From: Charlotte Watkins
Sent: 28 December 2023 14:52
To: Rebekah Morgan
Cc: Planning
Subject: RE: Application 22/03873/F: Land north and adjacent Mill Lane, Statton Audley - outstanding consultation request

With regard to the above application I have the following comments:

Client
JBM
Project:
Padbury
Drawing Title:
Site Layout Plan - 1 of 4
Drawing No: 1051745-ADAS-XX-XX-DR-PL-8001
Scale: 1:1000 at A1
Drawn by: A.F. Date: 26/07/22
Checked by: D.H. Date: 26/07/22

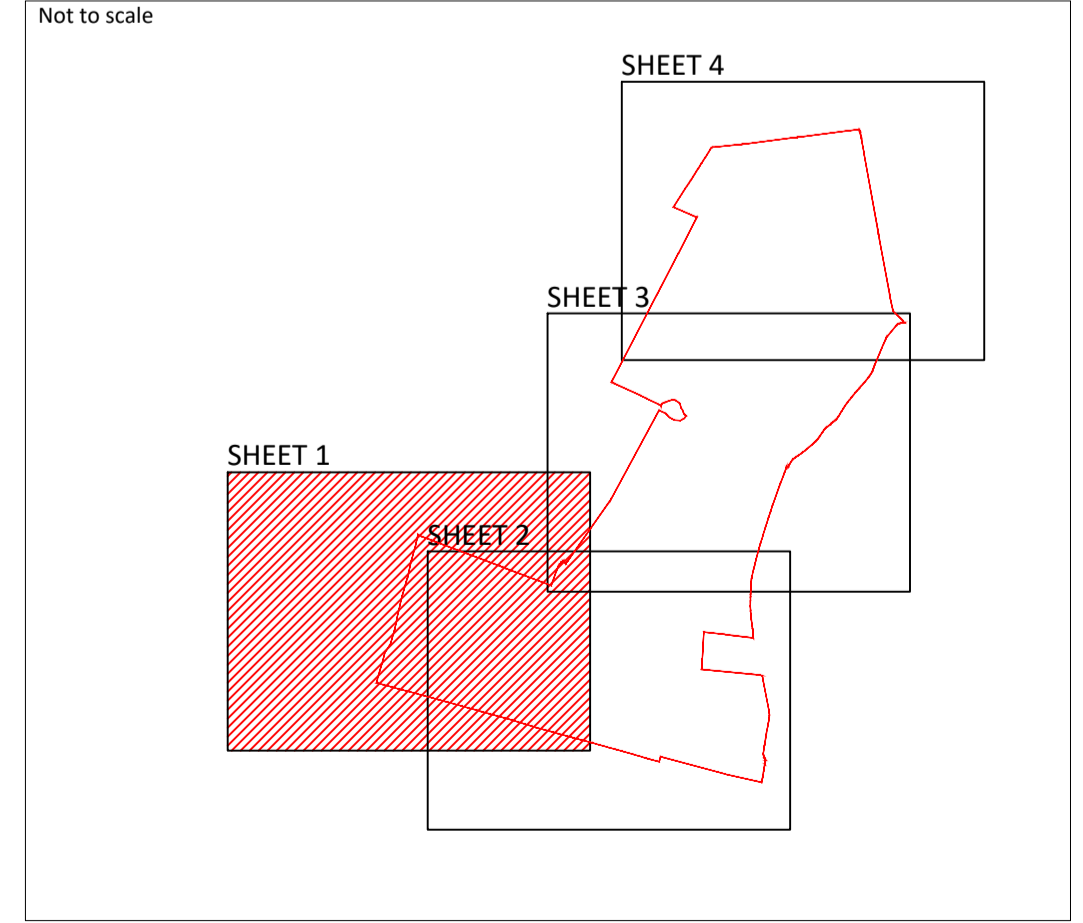
I would concur with BBOWT that the grassland mix proposed for the majority of the site could be improved in order to maximise biodiversity opportunities on site, but appreciate that the current proposed grazing mix would still constitute an improvement for wildlife over the current arable usage.

If the site has to be fenced it would be better to have the fence raised such that smaller mammals (badgers hare etc..) could use the site unimpeded. Gates run the risk of malfunctioning and animals being trapped. The fence could be raised a sufficient height to allow free access underneath for smaller mammals whilst preventing access by deer.
